From: Sarah Burrow <Sarah.Burrow@arun.gov.uk>
Sent: 16 February 2021 14:51
To: Anita Gardner <Anita.Gardner@arun.gov.uk>
Cc: Laura Gibbons <Laura.Gibbons@arun.gov.uk>; Paul Cann <Paul.Cann@arun.gov.uk>
Subject: RE: Planning Consultation on: CM/53/20/PL

Engineers Comments Regarding Surface Water Drainage

SITE PLAN
SCALE 1:500 @ a3

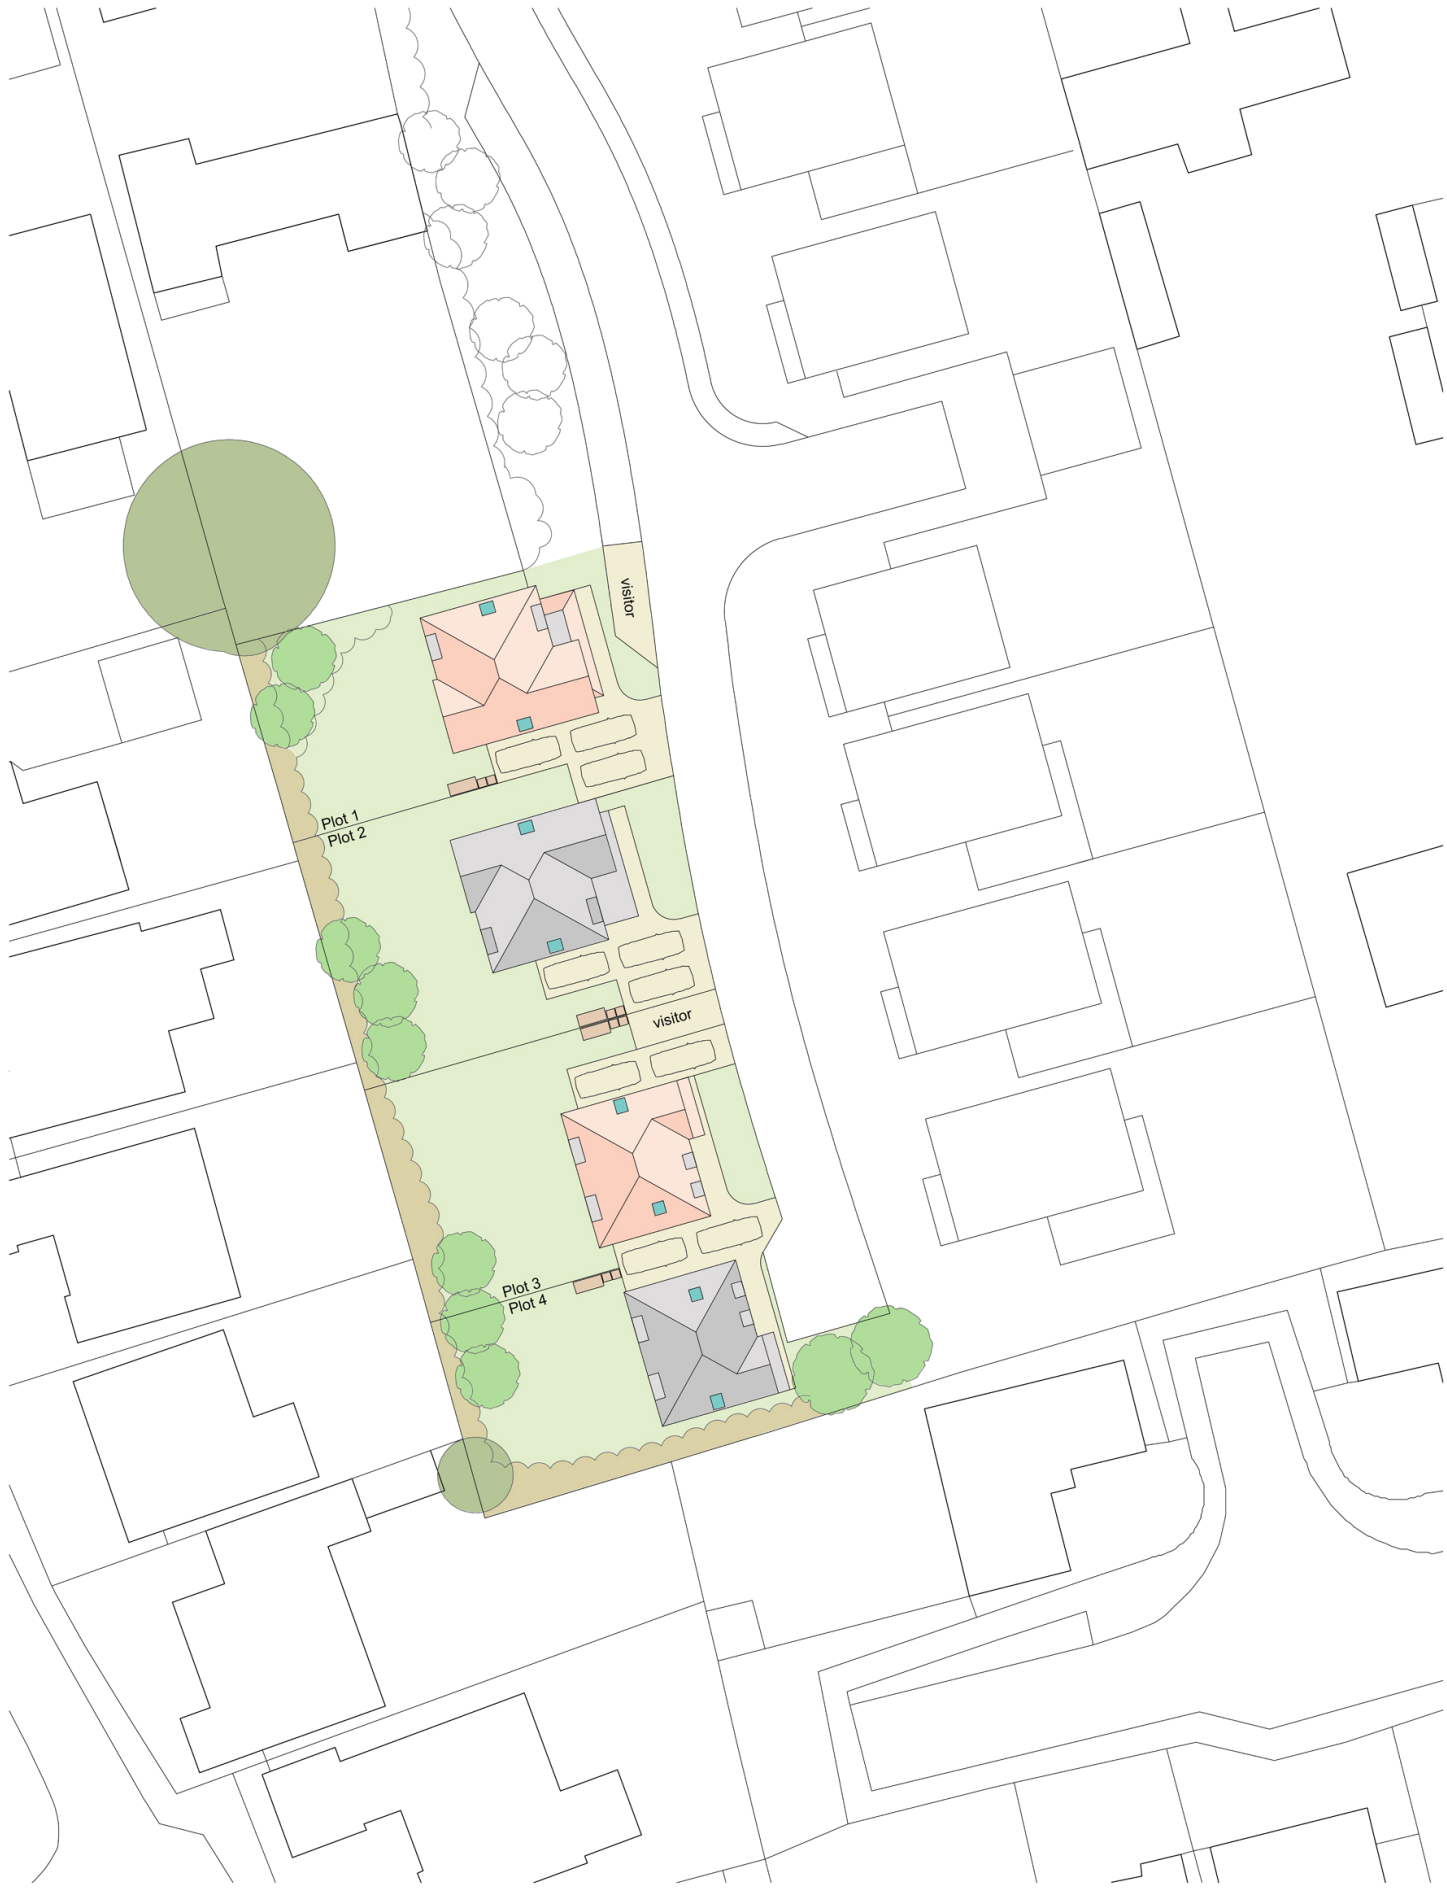
I have spoken to our drainage engineer and there is an issue that any drainage is likely to be dependant on the adjacent site Scyld and it is not clear from the details submitted that the developers of that site would be willing to allow your client the opportunity to utilise any drainage agreed for their site. It seems unlikely that this can be resolved quickly so I would suggest that the application is withdrawn to allow time for discussion between the relevant parties. The application expires tomorrow so I would be willing to agree to an EOT until 18-02-2021 to allow you time to discuss with your client, but this would need to be agreed with you by return. If the identified tree, drainage and plot position issues can't be resolved in the short term the application is likely to be refused.

Ground investigation results from neighbouring sites evidence that infiltration is highly unlikely to be suitable at this location due to the presence of high groundwater (0.3mbgl). Therefore, a connection to the watercourse along Horsemere Green Lane is likely to be required. It is unclear how this will be possible as the site is land locked and the shallow falls across the site to the watercourse. We note that the site access is via the proposed development at Scyld. We would therefore suggest that the two sites will require a drainage scheme that works together, however the drainage scheme for Scyld as it currently stands would not have capacity to drain any additional water.

To overcome our holding objection we request that the applicant submits details of how they propose to drain the site in a worst case/no infiltration scenario. If this information is not provided prior to determination it is likely that the layout will unduly bias the design of surface water drainage and could result in flooding being increased elsewhere.
